This relates to the doors of garages to Sunflowers, The Granary and Tryne Barn within the curtilage of Grade II Listed buildings, now extensively converted.

APPLICATION Y/19/18/L

Site Address: Hobbs Court Bilsham Road Yapton BN18 0JY

Description of Works: Variation of conditions following a grant of planning permission Y/70/15/L for Condition 2 - Substitute plans to amend the design.

client	project	drawing	date	drawn	drawing no	revision
Sue & Iain Kerr Lorna & Lee Mason Sasha Osbourne	The Granary, Tryne Barn and Sunflowers, Hobbs Court Bilsham Road, Yapton, BN18 0JY	Garage Block Floor Plans & Elevations	Jan 18	pd	0250 / 100	B
			scale 1:100, 1:10 @ A3	CAD file name:

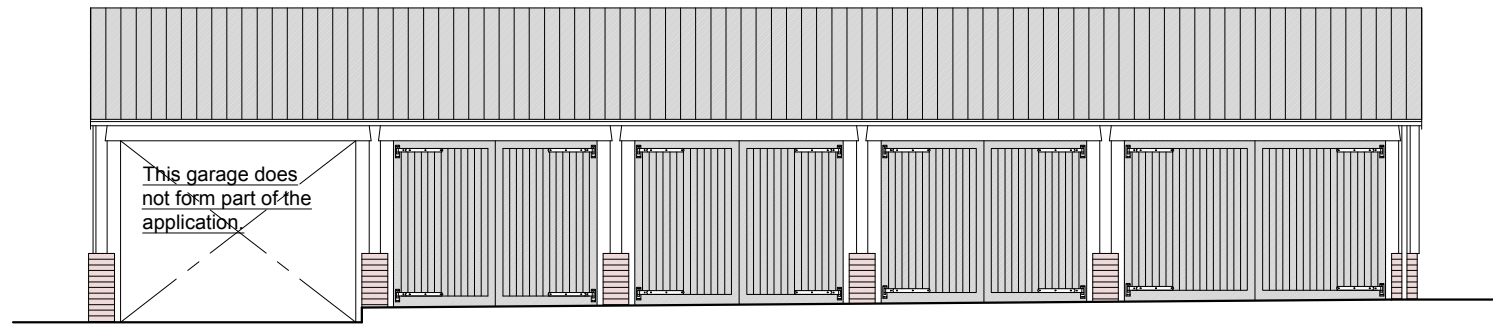
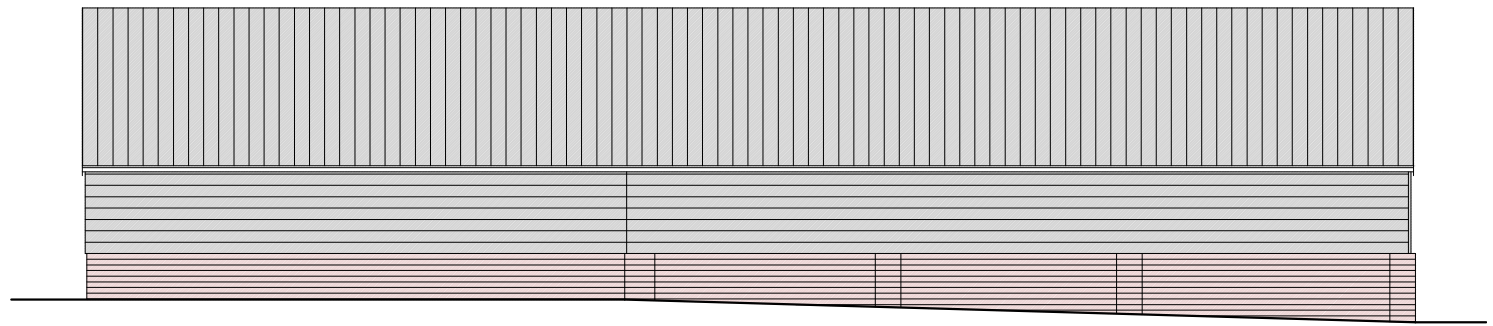
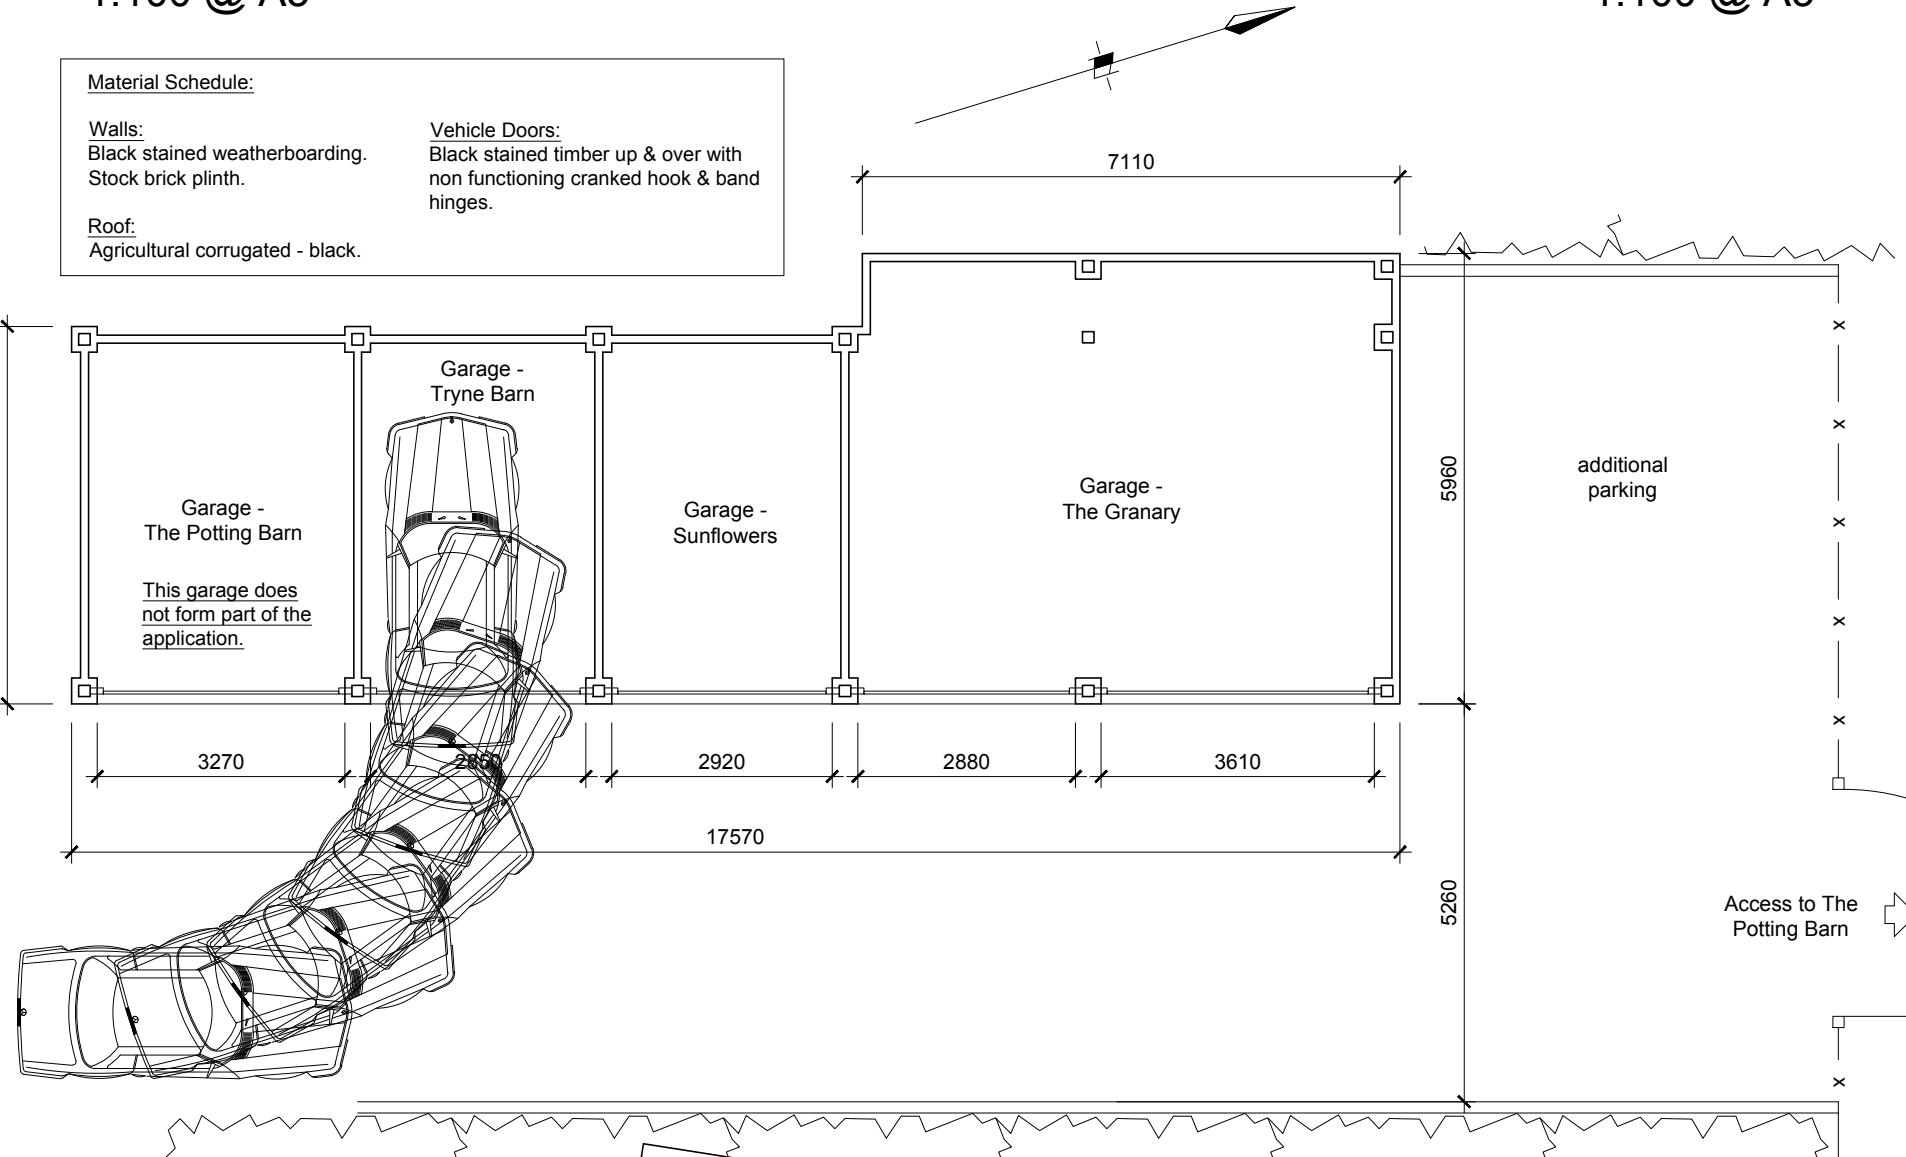
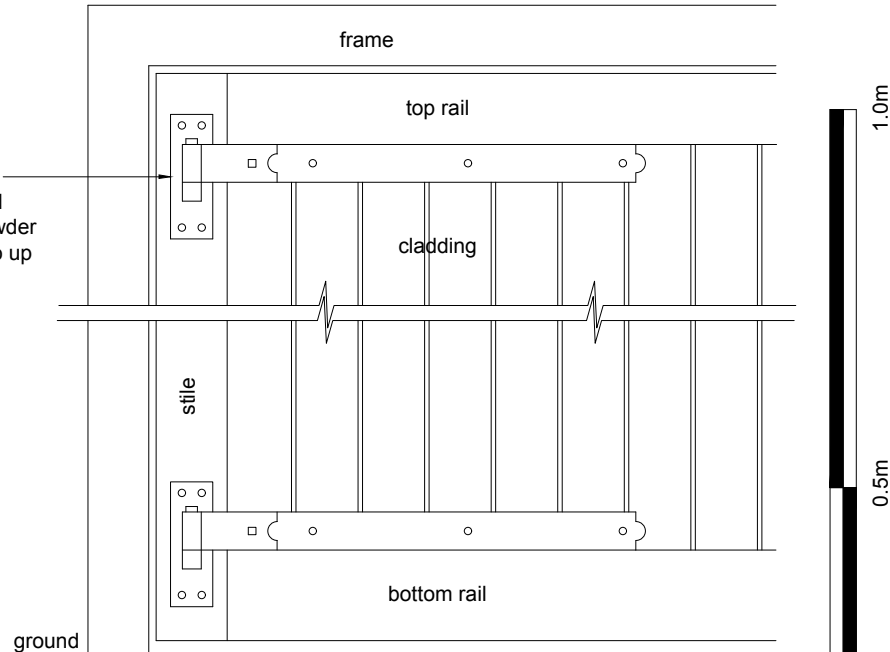
This proposal site has been the subject of several pre-application discussions, and it is considered that the submitted plans are appropriate in terms of hinge style, manner of door opening, timber profile and black-stain finish. It is however regrettable that the doors are not the more solid side-hung/strap-hinge opening as per the original approval, as would better suit the historic environment.

I recommend that the application be approved.
